Please ask for: Nicola Moore
Email: nicola.moore@arun.gov.uk
Telephone: Ext 37944
Our Ref: P/40/21/CLP
Your Ref:
Date: 29th March 2021

Lawful Development Certificate for a Proposed Use or Development

Development: This proposal is to convert an existing conservatory on my property to a solid walled construction. The current low wall (770mm) will remain in place and solid walls will replace the existing glazed sides and front. Additionally the plastic roof will be replaced with a solid roof. The build will have two sky lights (1000mm x 2500mm) and a bi-fold door (3000mm x 2100mm) facing the same direction as the existing door. There will be no additional windows on the build. The dimensions of the construction will remain the same as the existing conservatory with no planned alternations to any other feature other than those previously mentioned. This will all be subject to any requirements from building control.

Location: 50 St Thomas Drive Pagham PO21 4UA

50 St. Thomas Drive, Bognor Regis, PO21 4UA

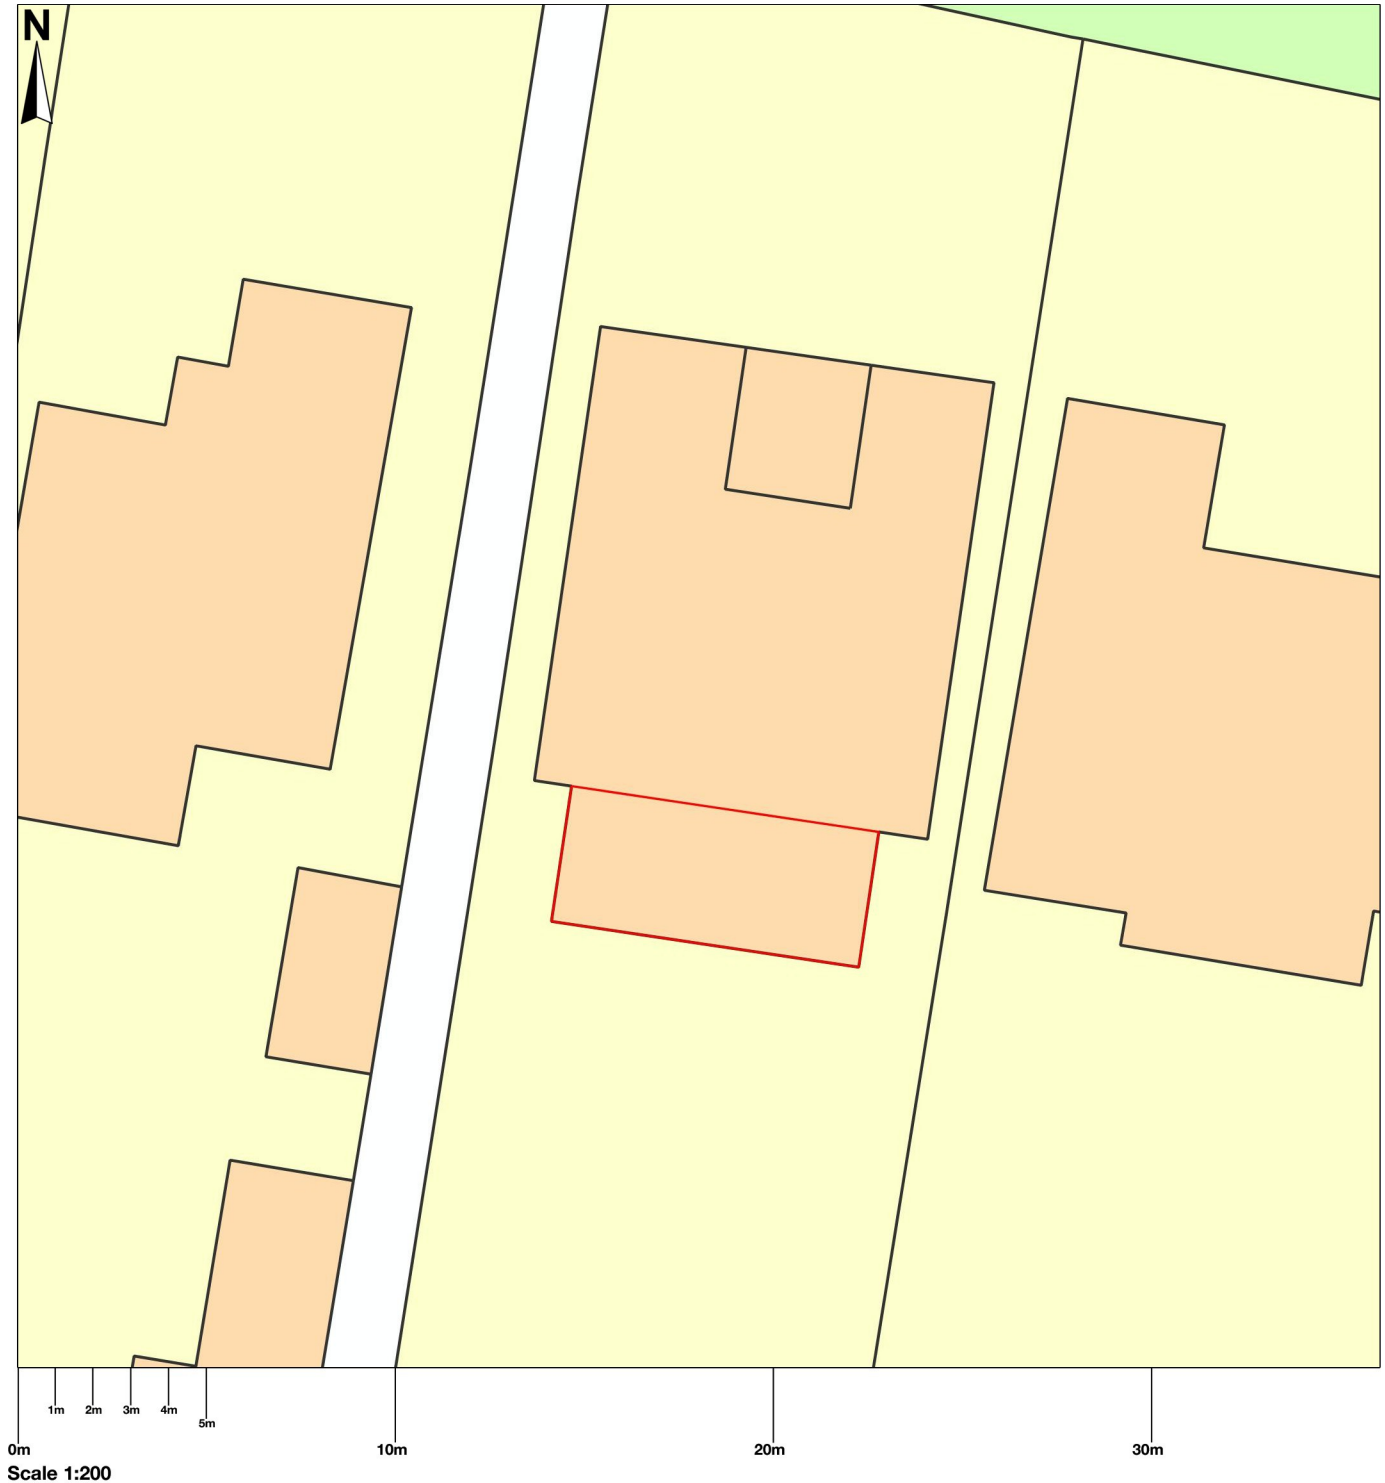
Location Plan

The submitted Location Plan is not to scale. Please re submit ensuring the scale is correct at either 1:1250 or 1:2500 for rural areas. Further details of what must be included on the plan can be found in the Validation Requirements List.

Existing Floor Plan

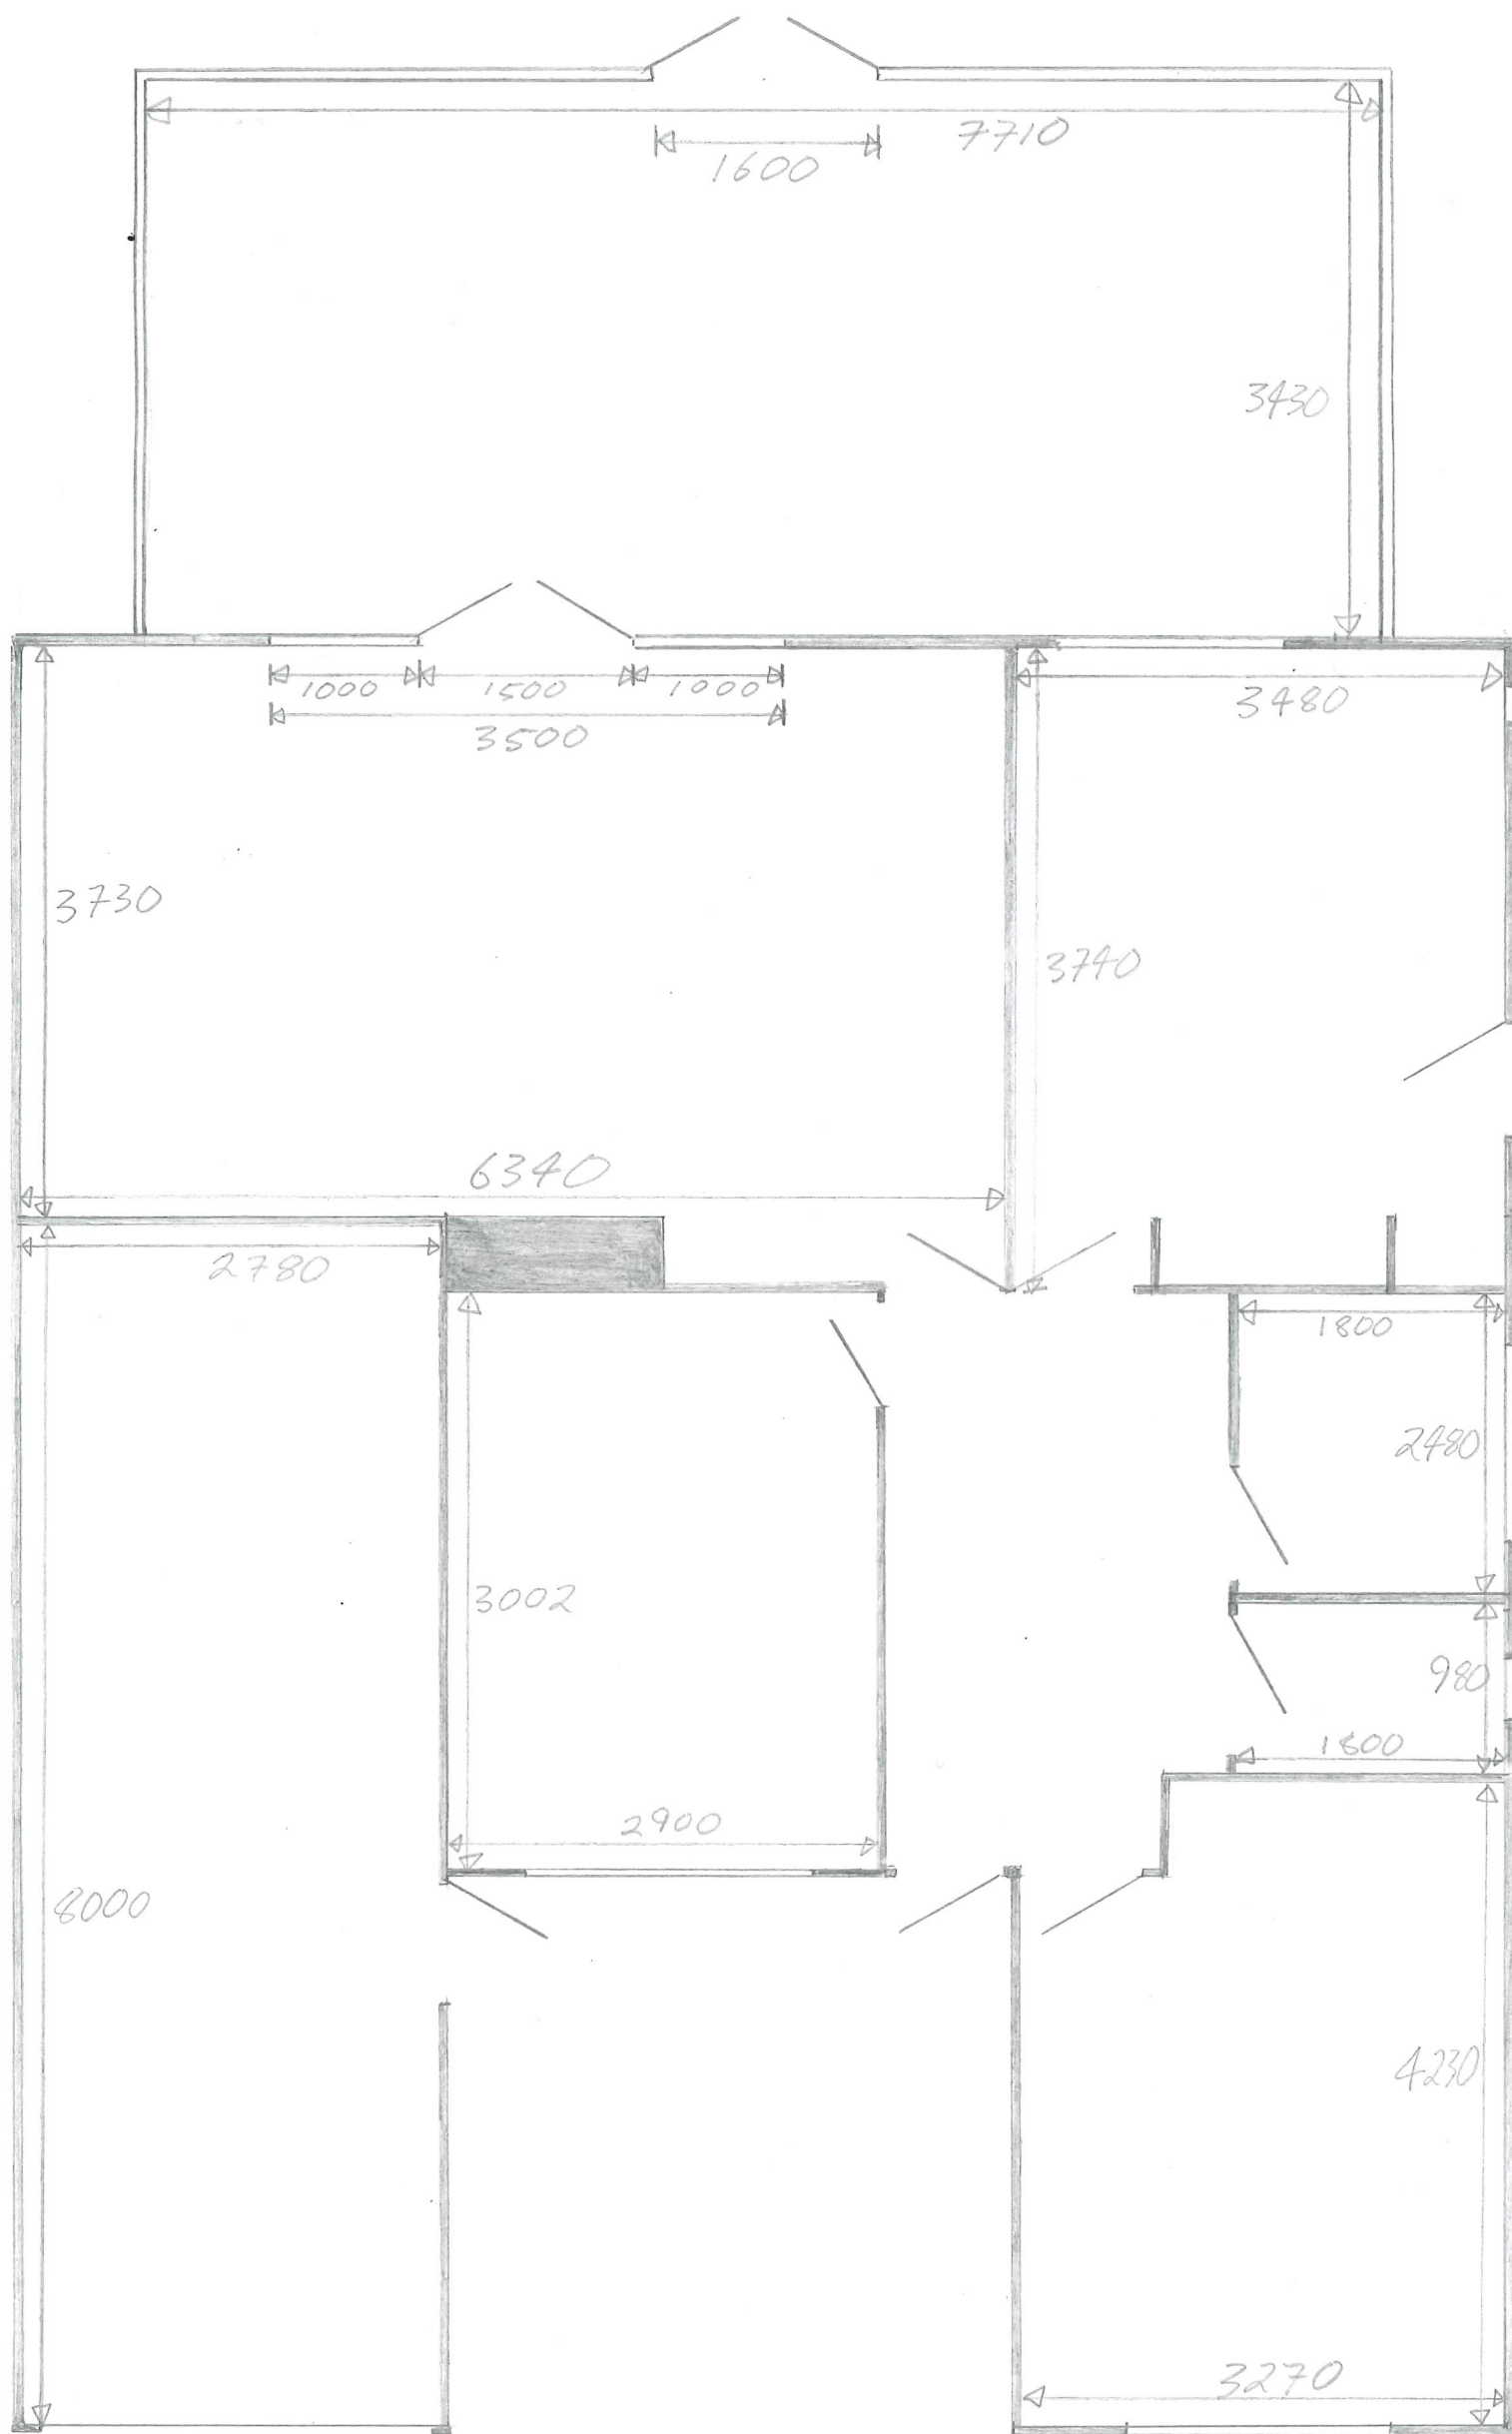
Floor Plans

Please submit 1 electronic or 3 paper copies of clearly labelled existing and proposed floor plans at a scale of 1:50 or 1:100. Further details can be found in the Validation Requirements List.
